From: Simon Davis <Simon.Davis@arun.gov.uk>
Sent: 21 July 2021 14:20
To: Planning.Responses <Planning.Responses@arun.gov.uk>
Subject: FW: Y/76/21/DOC Condition 5 Flint Walls

Further Conservation Officer Consultation Response

Development	YAPTON		
Location	NORTH_END_ROAD_YAPTON		
Marketing Name	-		
Drawing Title	FLINT_WALL		
Drawing Number	783-DET-002		
Revision	-	Scale @ A1	1:10_ & 1:200
Drawn By	SK	Date Started	24.05.2021
Checked by		Date

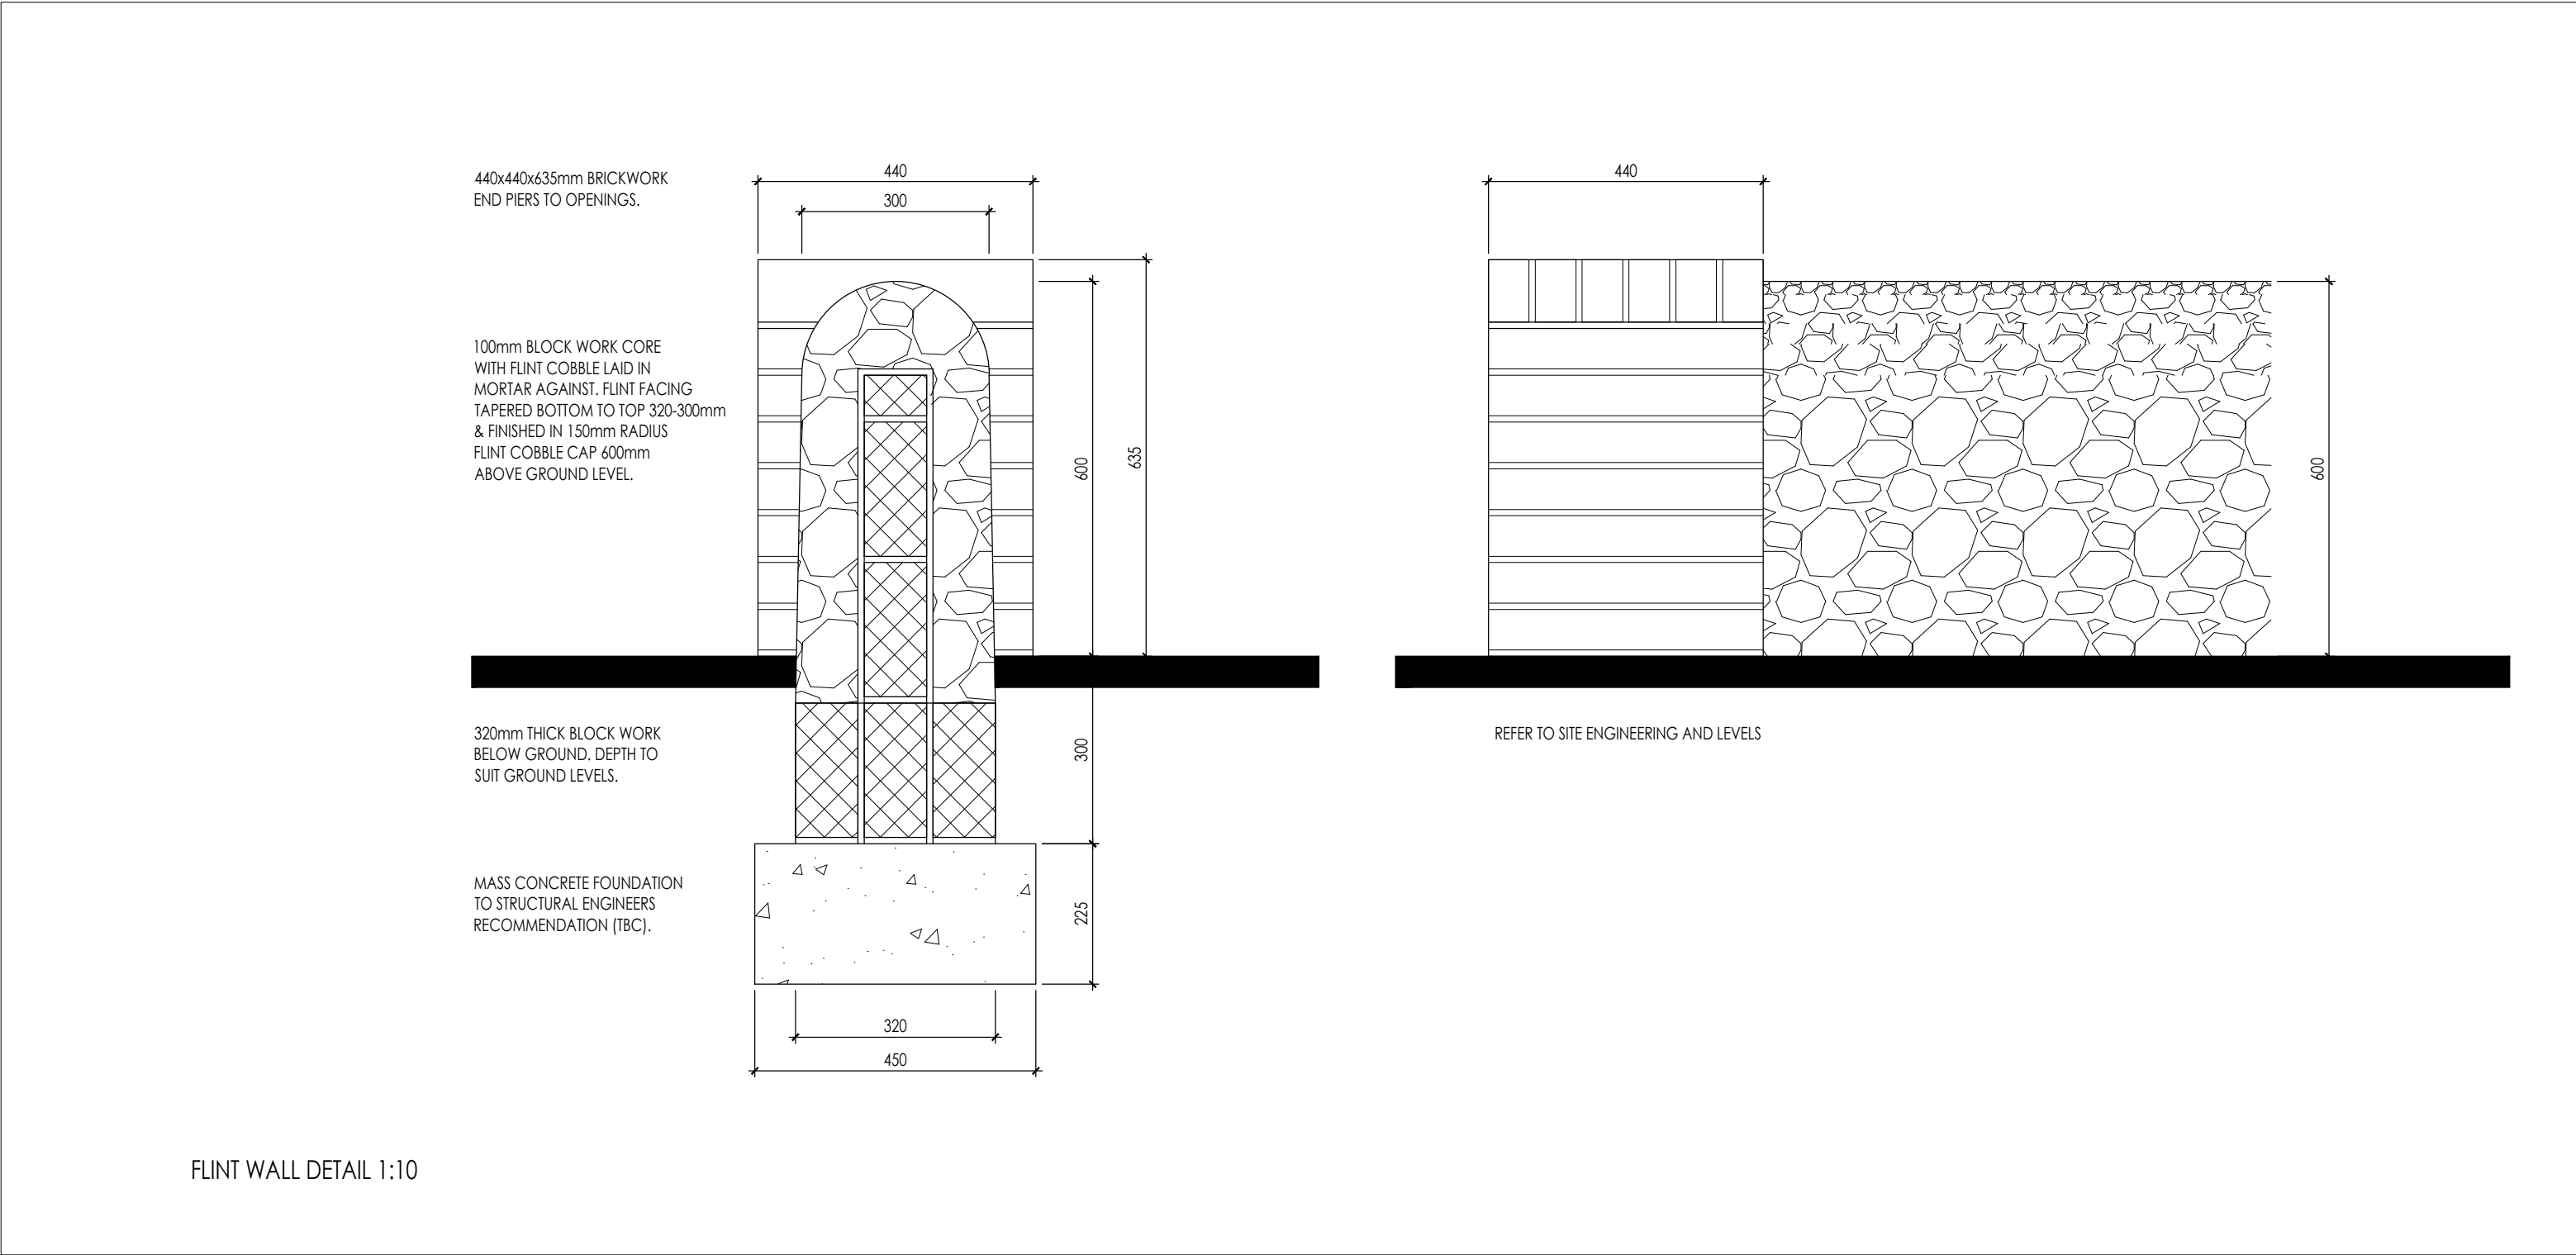
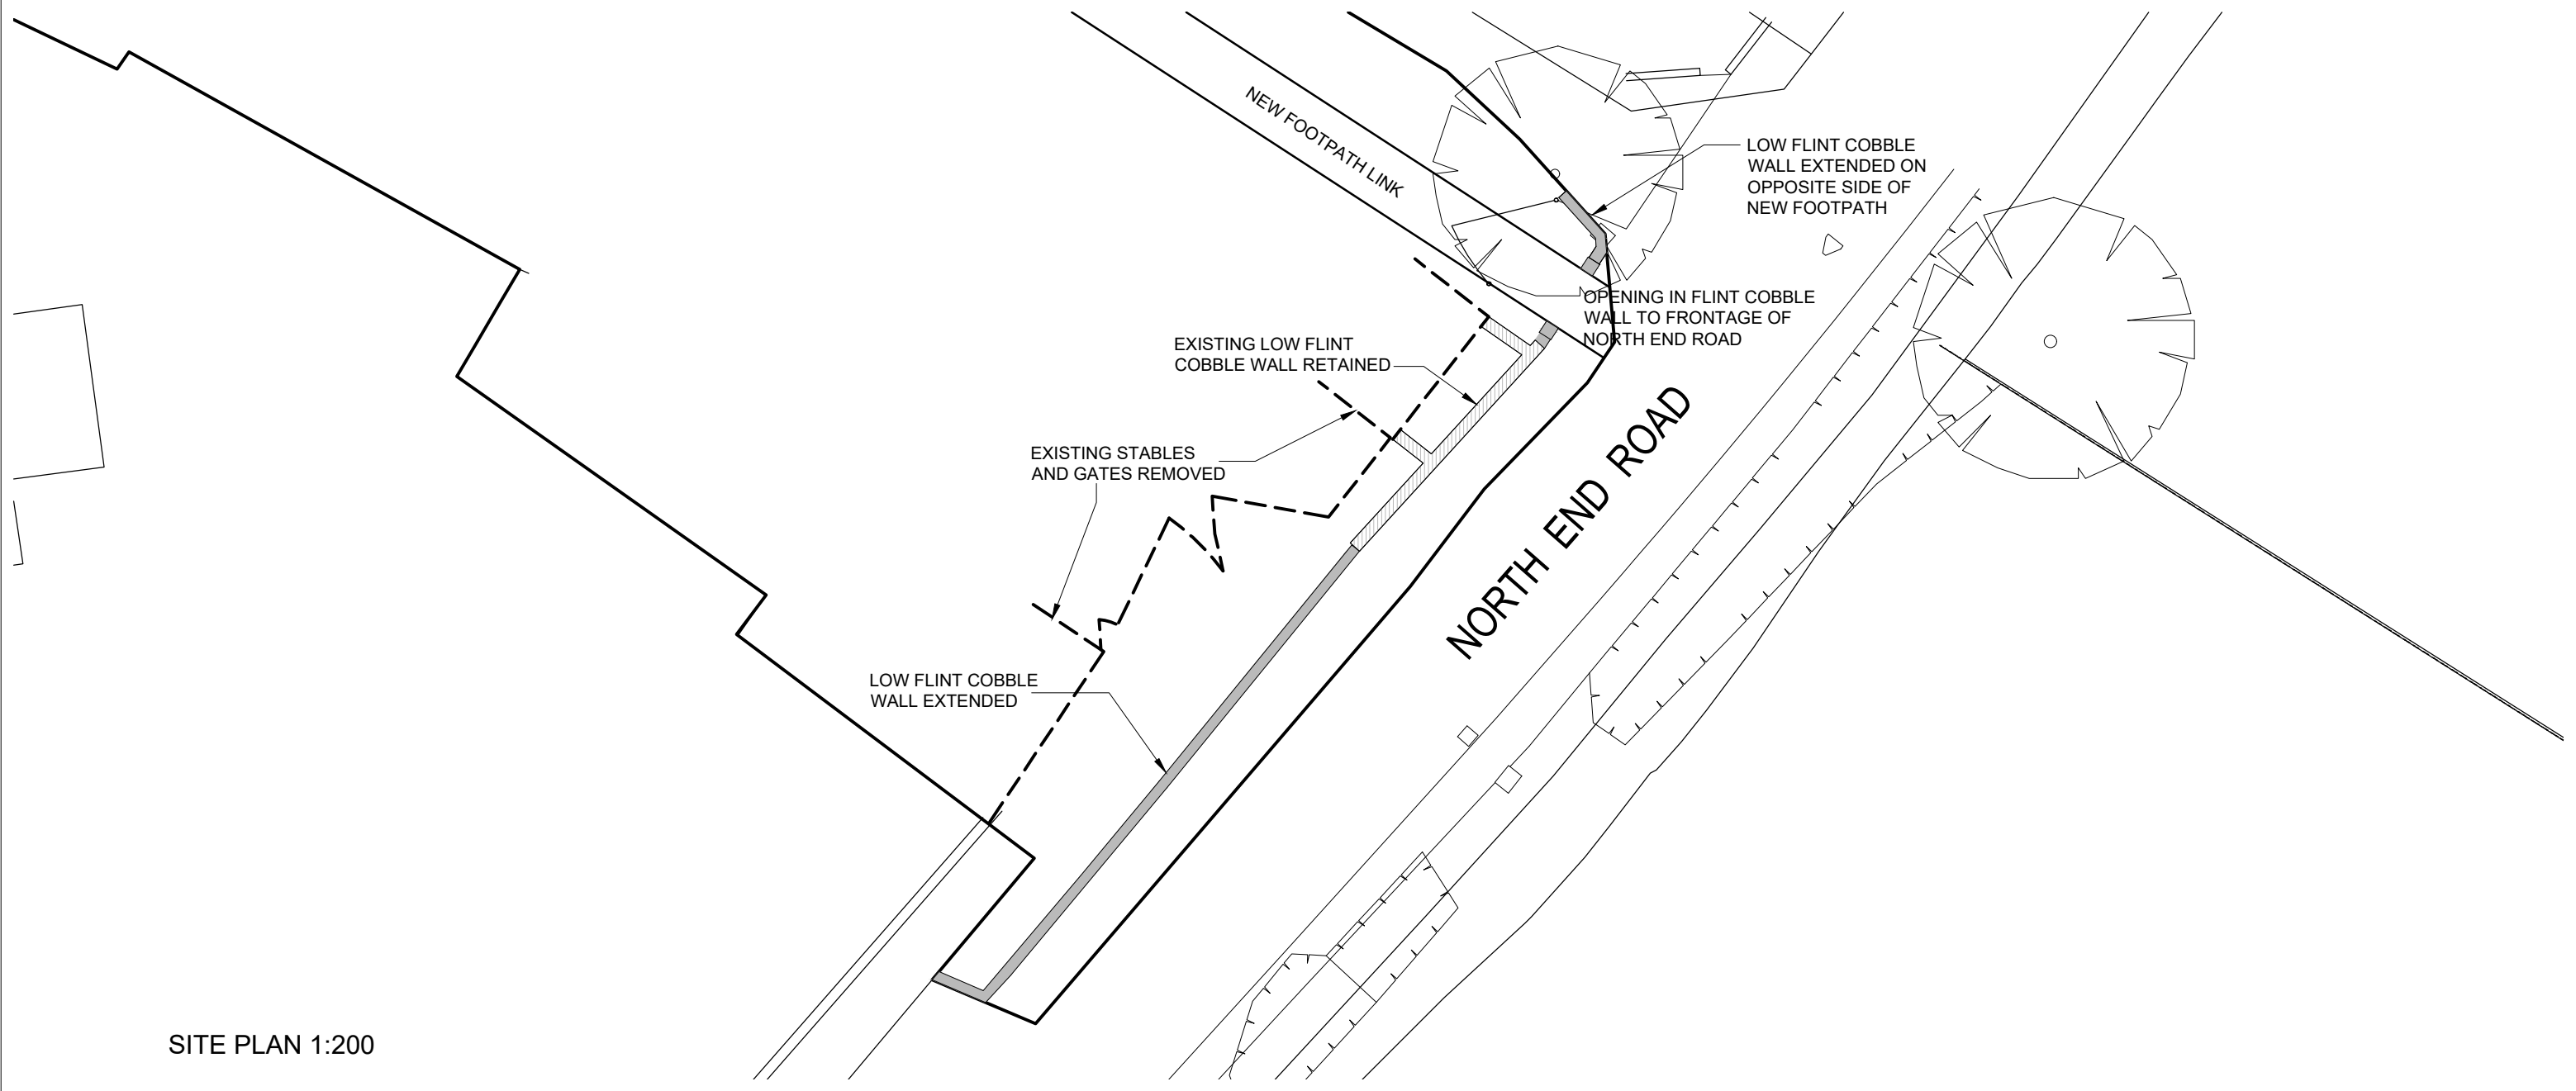
"The design of the flint wall seems to be generally acceptable and appears to replicate the existing wall. However, it is not clear how the southern end of the new section of flint walling will connect back to the neighbouring walling. At present, it looks as though the new section of wall terminates in front of, but not connected to, the neighbouring flint wall. Is this correct. If so, it will leave a section without any walling. Please can this be clarified."

Simon,
The alternative approach as suggested by the applicant (of reducing the length and tying it into the existing wall) seems a logical and acceptable approach to me
Martyn

The short answer is there will be a gap. The reason for there being a gap is this is land that is outside the consent for the site and is not on land owned by Redrow Homes (so we can't build the wall)

The alternative is the wall is reduced in length and ties into the existing wall (see extract below).
